01/06/2020

**Scientia Project - Monte Sant Angelo Mercy College (SSD-10393)**  
**Response to Submissions**

Aditi Coomar  
Team Leader  
Social & Infrastructure Assessments

Figure 4 Elevation Comparison

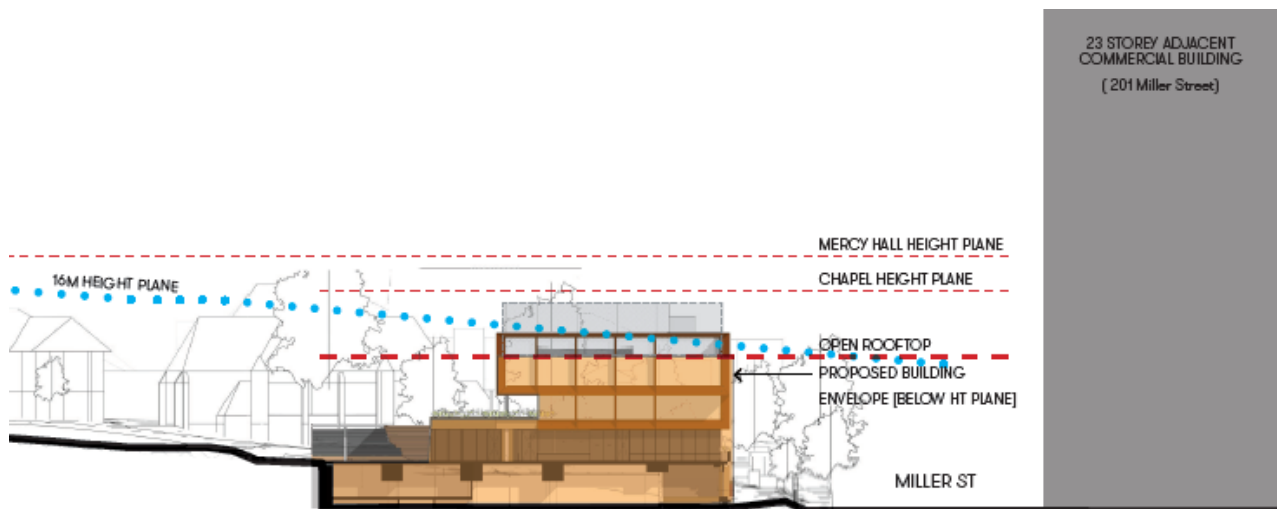
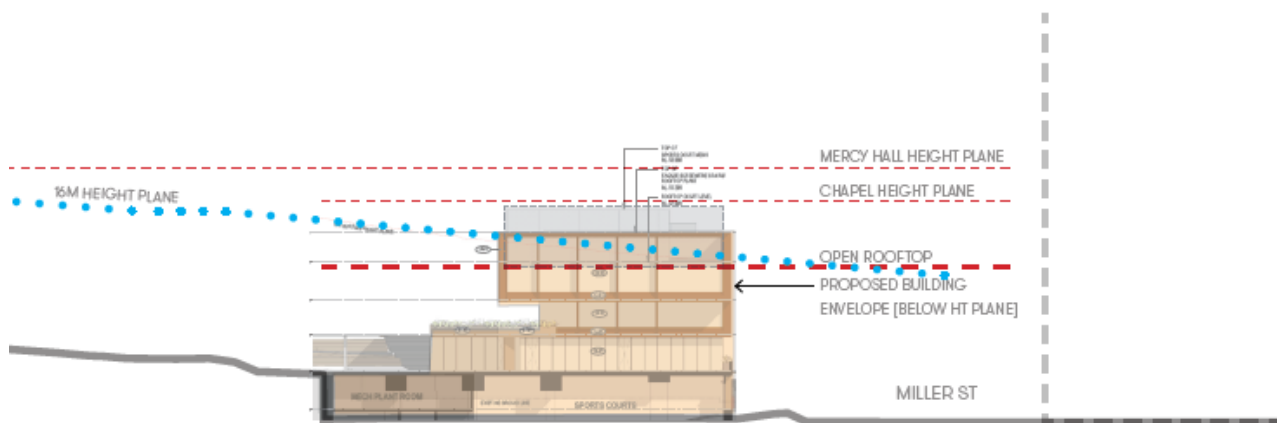
- reducing the overall bulk and scale of the building through façade refinement, architectural detail and articulation, and reduction or consolidation of program (where feasible).

Figure 12 Key Impact of Setback Increase

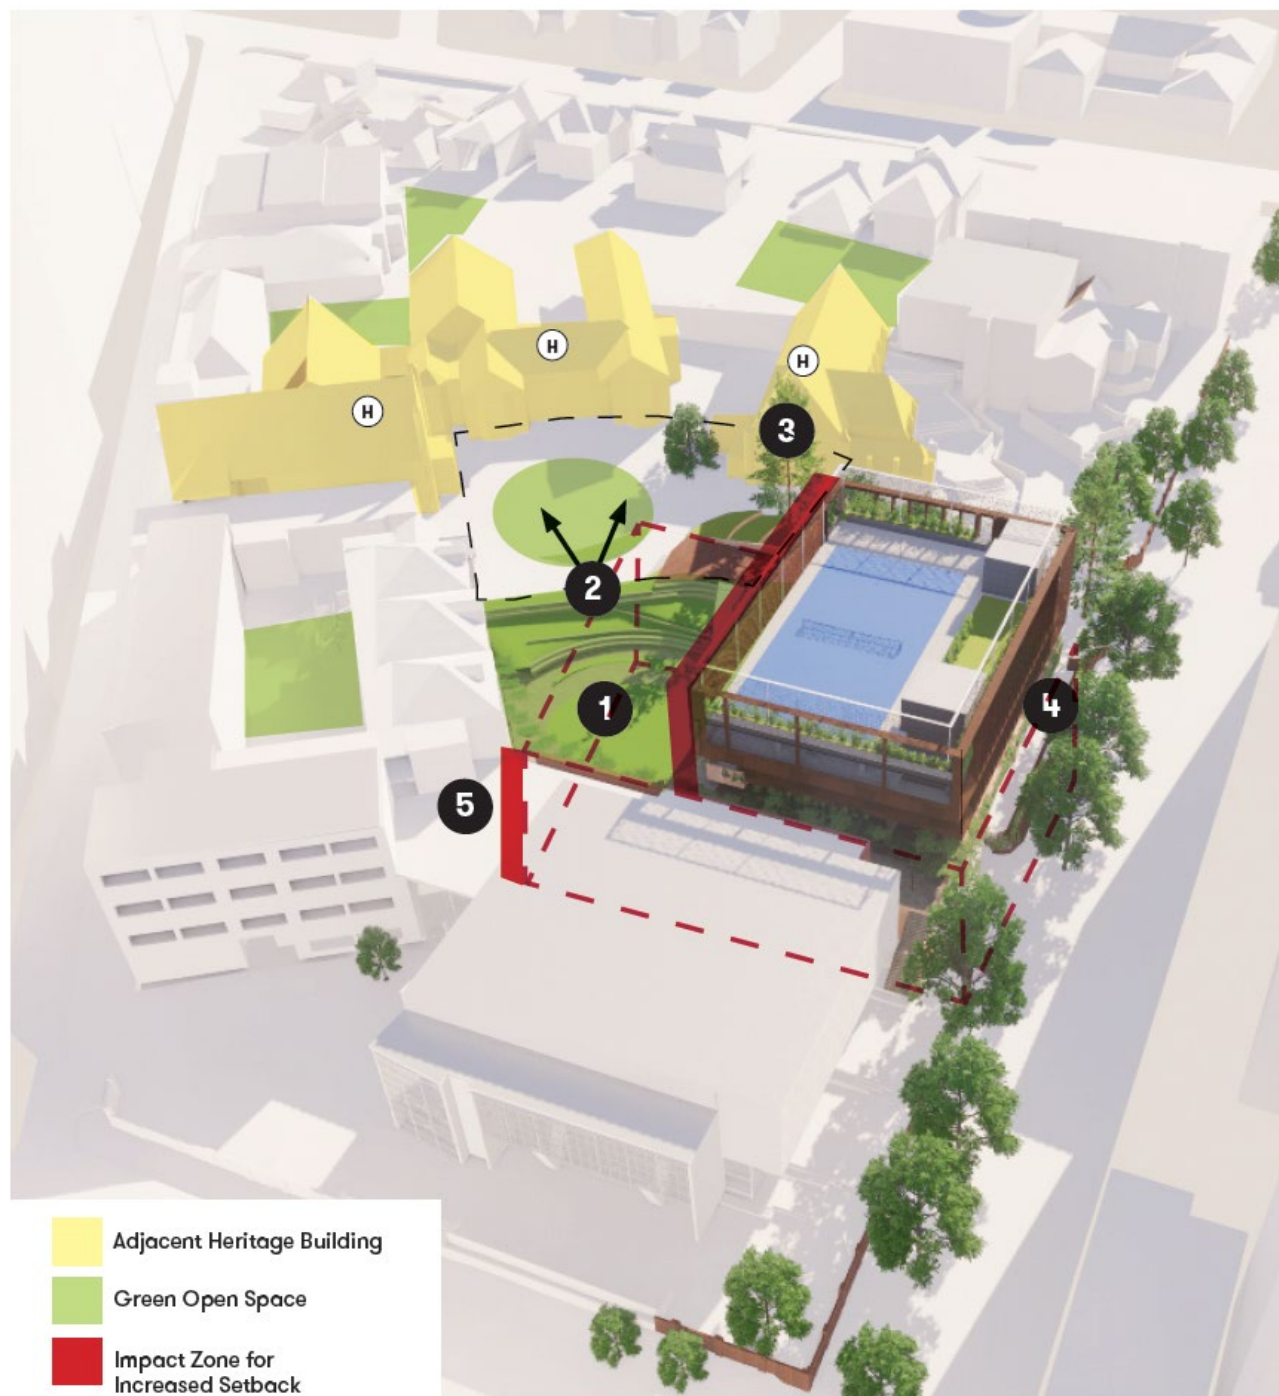
- a review of the setback of the proposed building from the Miller Street frontage (including location of the on-site detention tank within the setback) to explore opportunities for increased peripheral planting along this setback that may screen the building bulk and complement the streetscape. Alternatively, opportunities for planting on Miller street, along the entire building frontage should be explored.

Figure 13 Street Wall Treatment Comparison

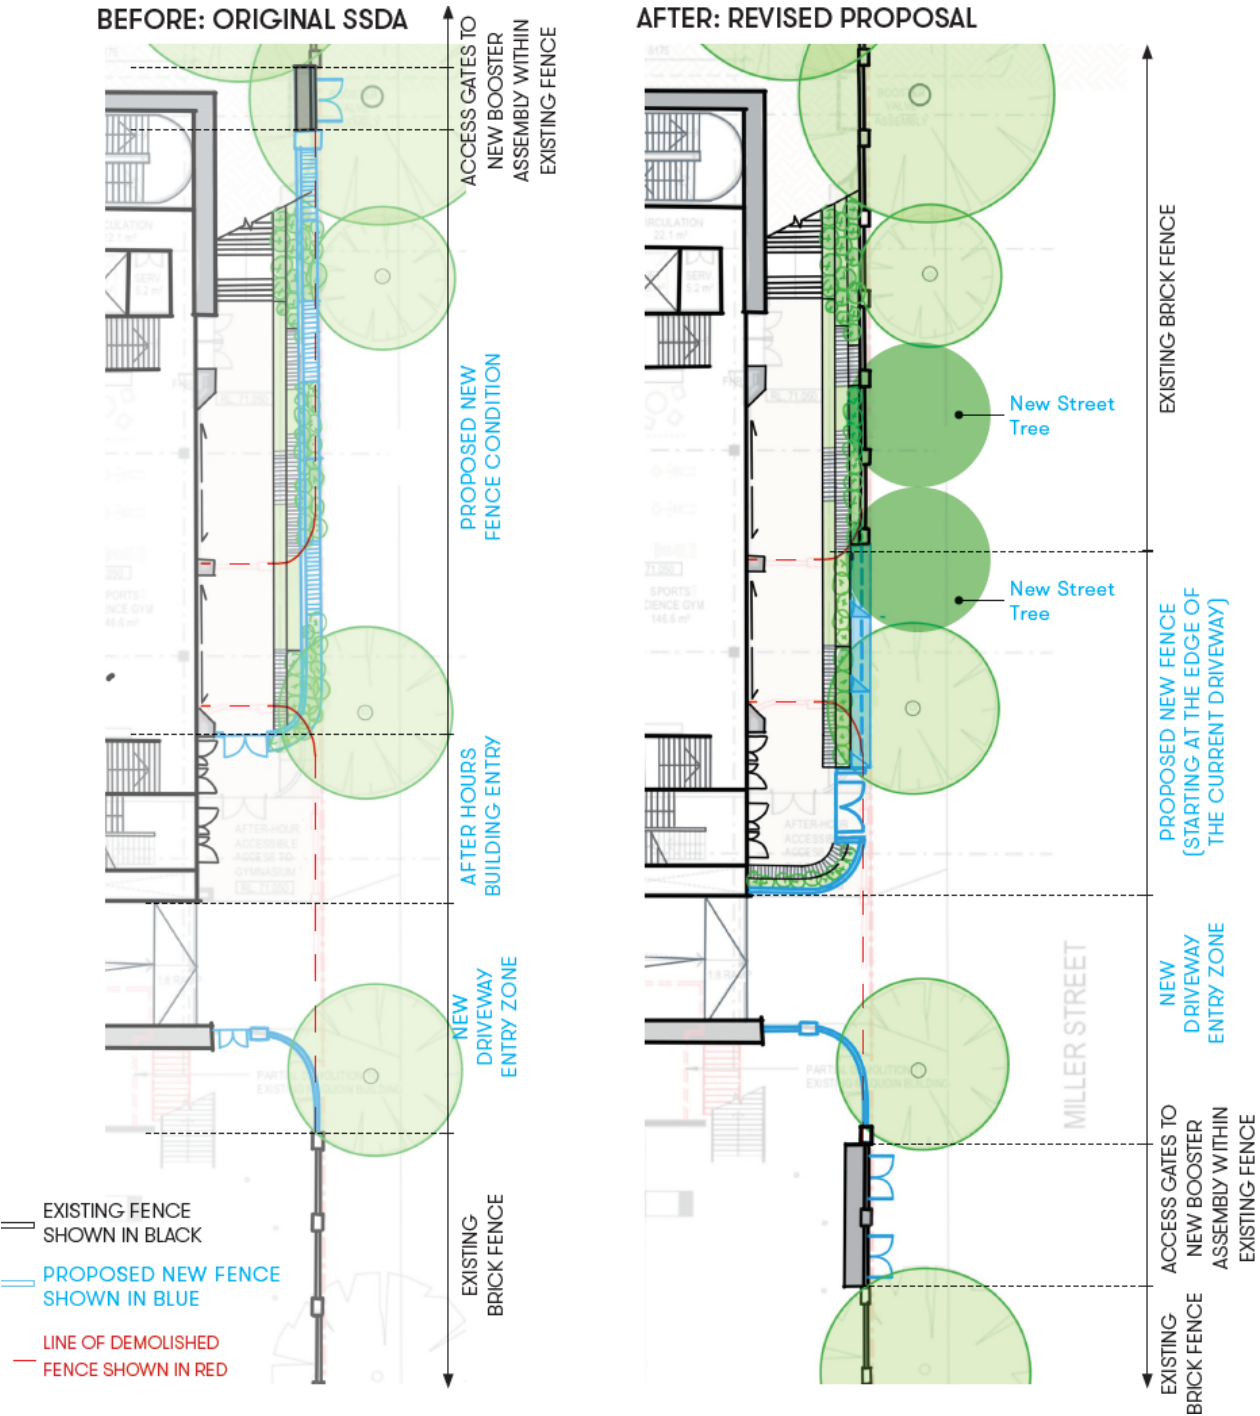
- Provide details of the retention of the boundary wall on Miller Street (heritage item of local significance), either in the form of an amended design or appropriate justification for the removal of this wall, consistent with North Sydney Council's request.

Figure 15 Street Interface Treatment

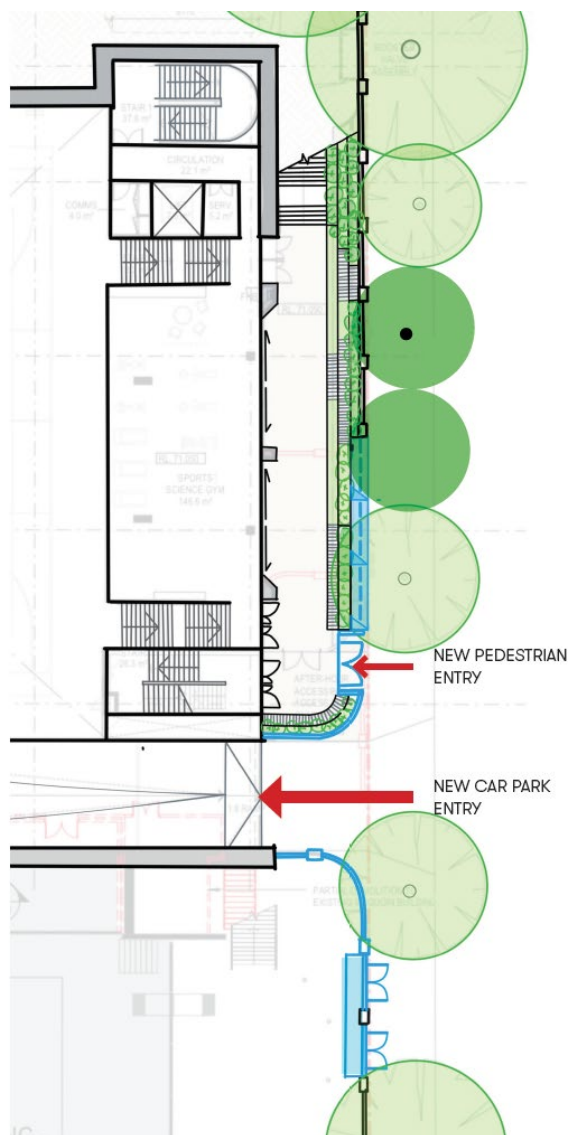
- including details of passive solar design strategies to ensure access to natural light and ventilation for all internal spaces.
  - incorporating Crime Prevention Through Environmental Design Principles (where applicable) for the external space between the gymnasium and Miller Street at Level 1 of the proposed building.

Figure 18 Updated Landscape Plan

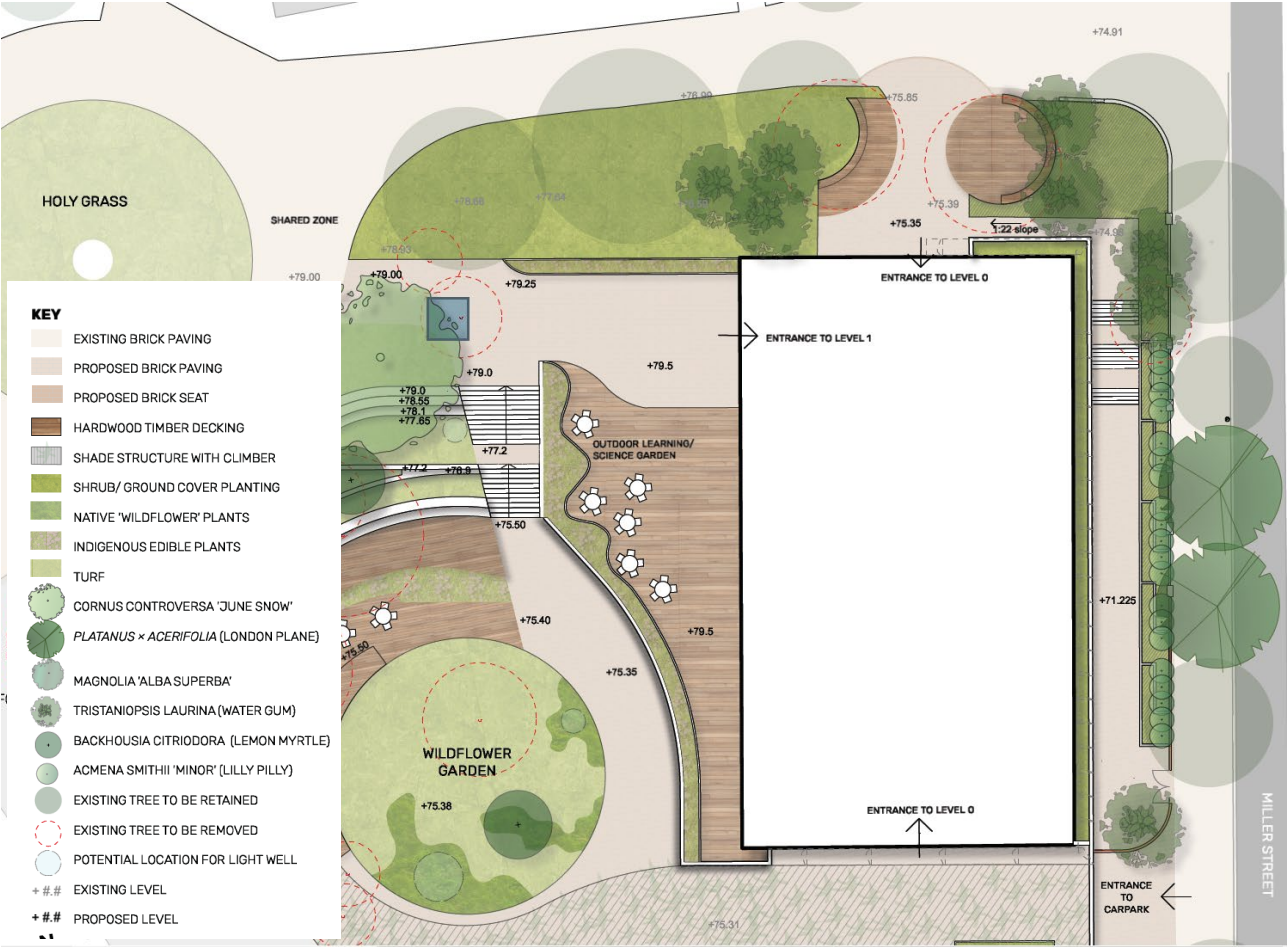
- opportunities to compensate for the loss of trees between the heritage listed chapel and the proposed building by proposing canopy trees on the northern side of the proposed development (within the identified curtilage of the chapel).
